Local Policing Support Team

Your Ref: BR/282/19/PL

RE: The Beach Hotel, former Mud Club, and 2-4 Waterloo Square Bognor Regis PO21 1SU

Thank you for your correspondence of 12th November 2019, advising me of the 'Redevelopment into 49 No Apartments consisting of 24 No1 & 25 No 2 bed apartments & 2 commercial units (A3 Restaurant & Café). This application affects the character 7 appearance of The Steyne, Bognor Regis Conservation Area & may affect the setting of a listed building.' at the above location, for which you seek advice from a crime prevention viewpoint.

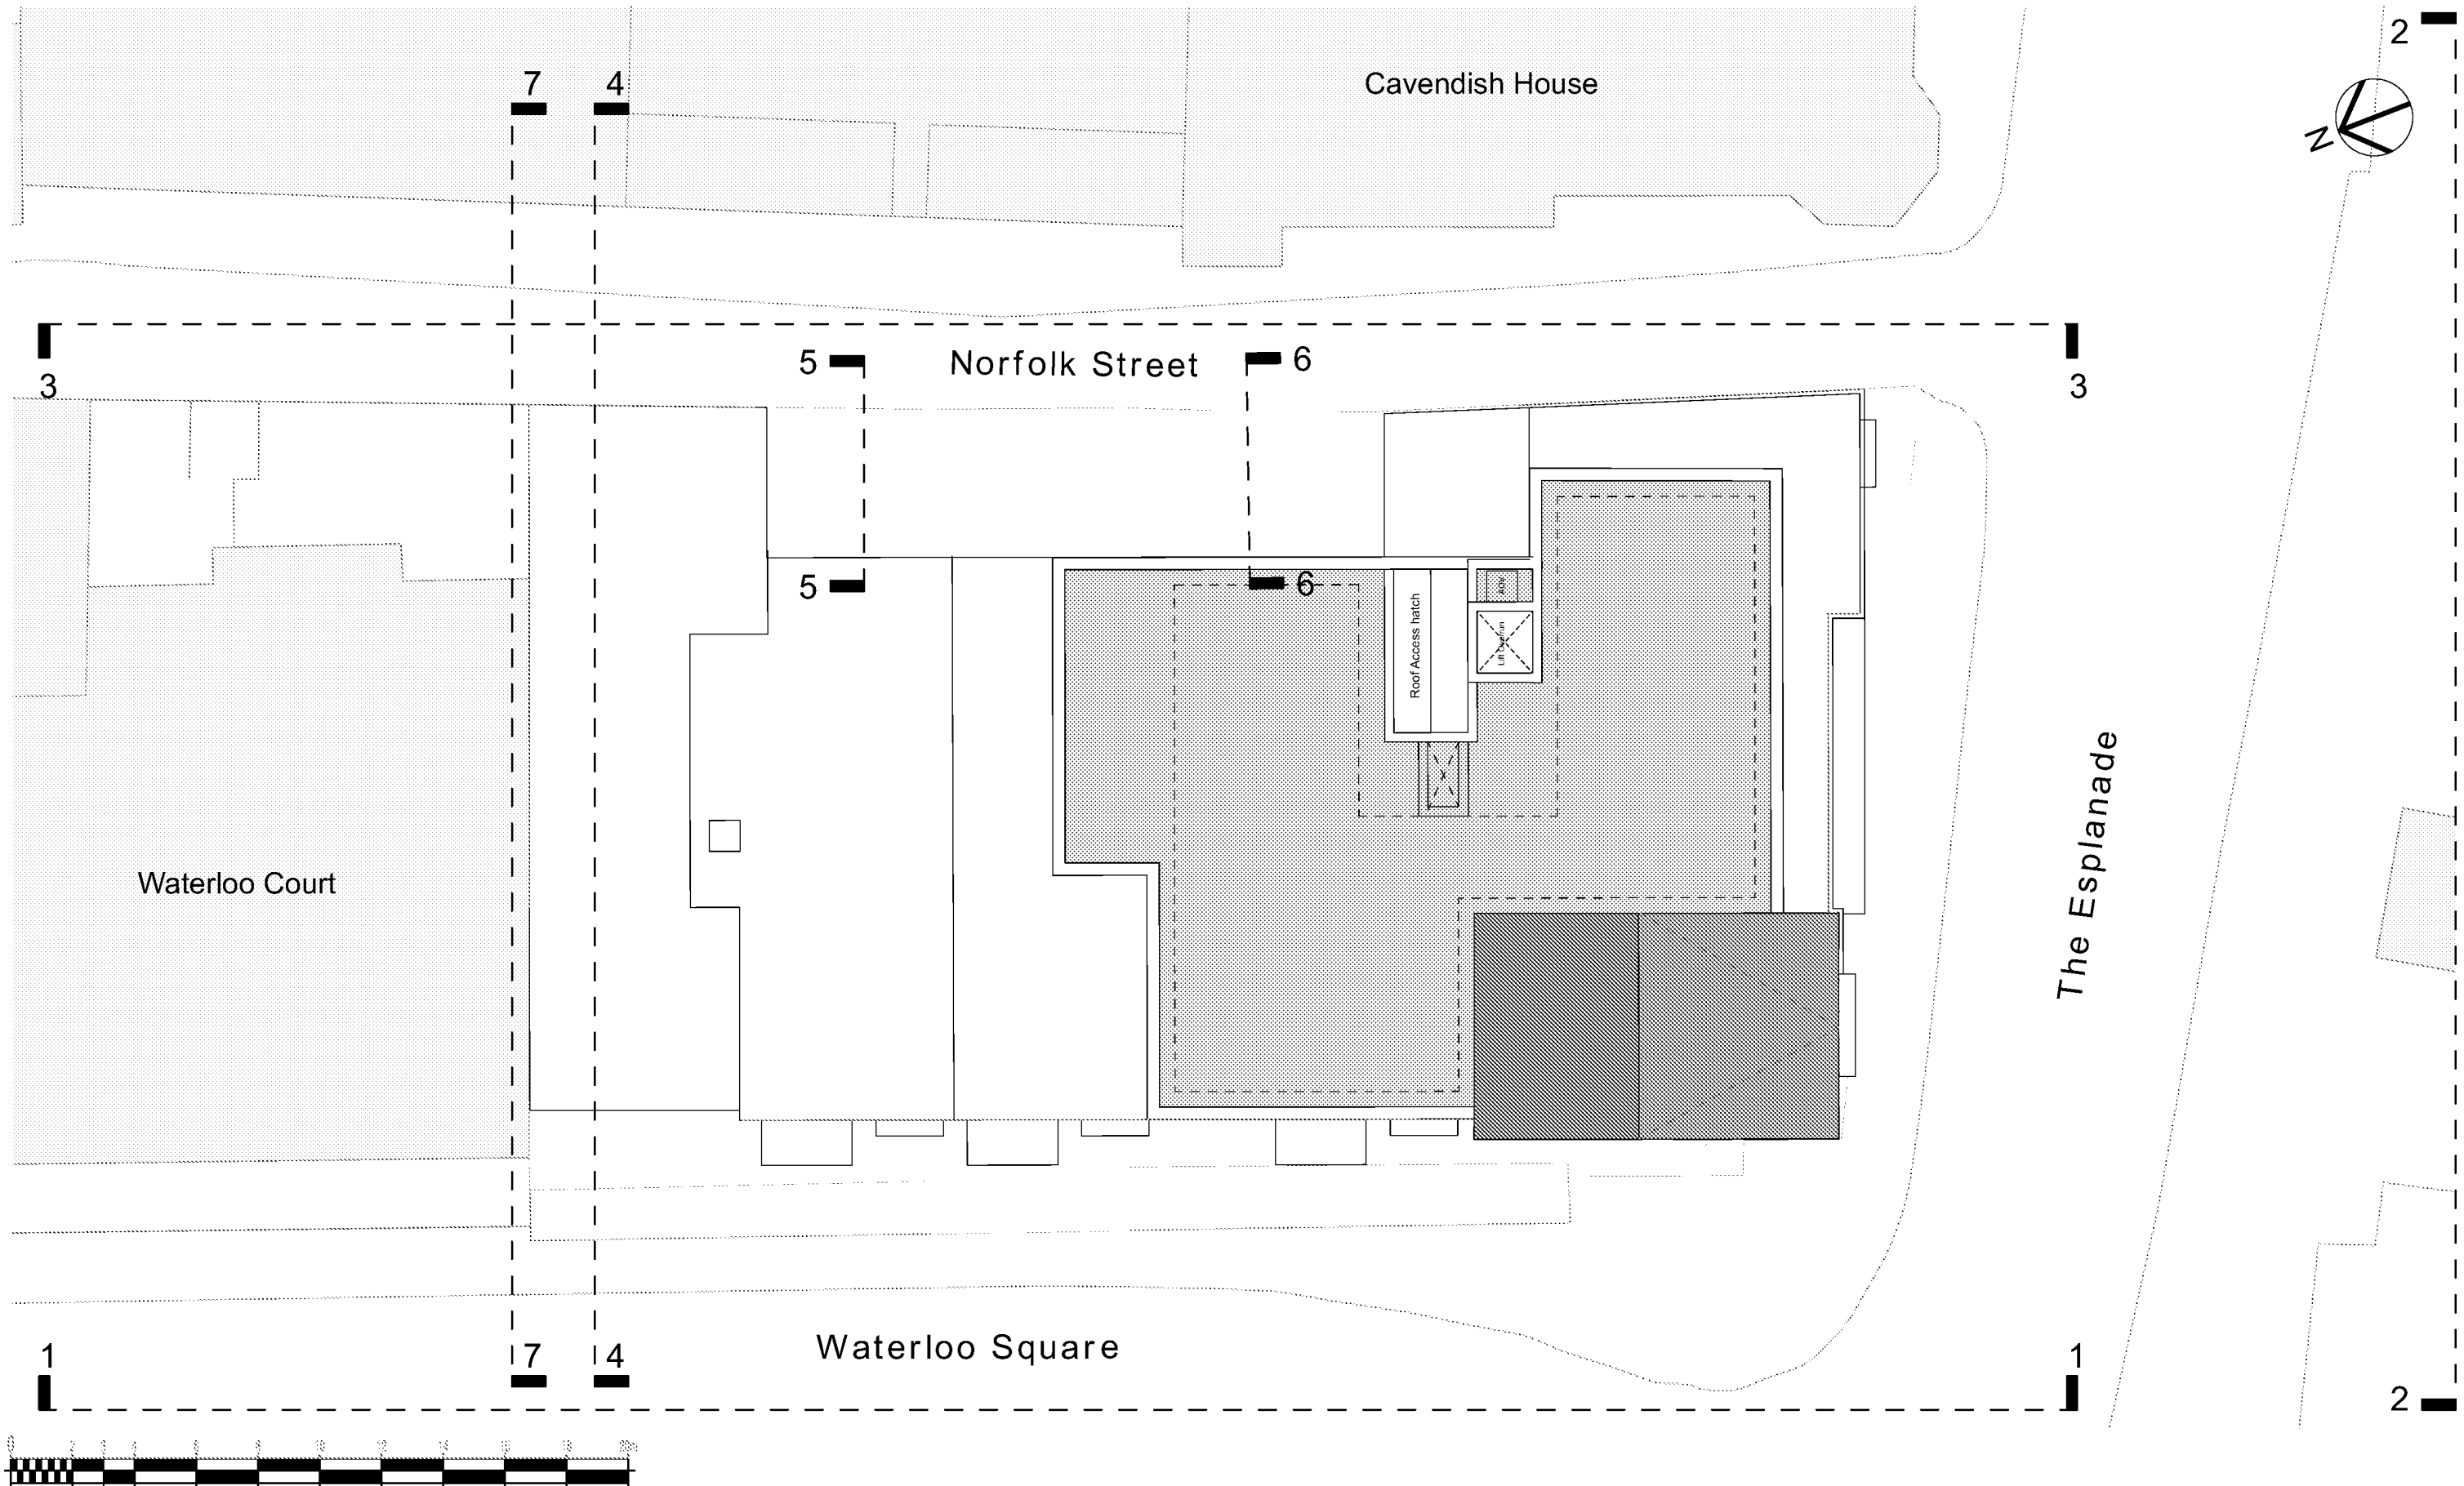
I note (drawing number 18.103.202) indicates a waiting space and traffic light position to be located at the entrance to the underground car park. However there is no indication of the security to protect the entrance. This area of the town is highly likely to be well used during the summer months in particular and the vehicles and their owners using the underground car park potential targets for crime as they are out of view and isolated.

Where a development incorporates an underground car parking facility, the following security enhancements are required which require an access control system for all vehicular and pedestrian entrances to prevent unauthorised access into the car park by either vehicles or on foot.

Inward opening automatic gates or roller grilles must be located at the building line or at the top of the ramps to avoid the creation of a recess. They must be capable of being operated remotely by the driver sitting in the vehicle. (Chapter 55.3 through to 55.3.7 provides additional information regarding lighting paintwork and CCTV considerations)
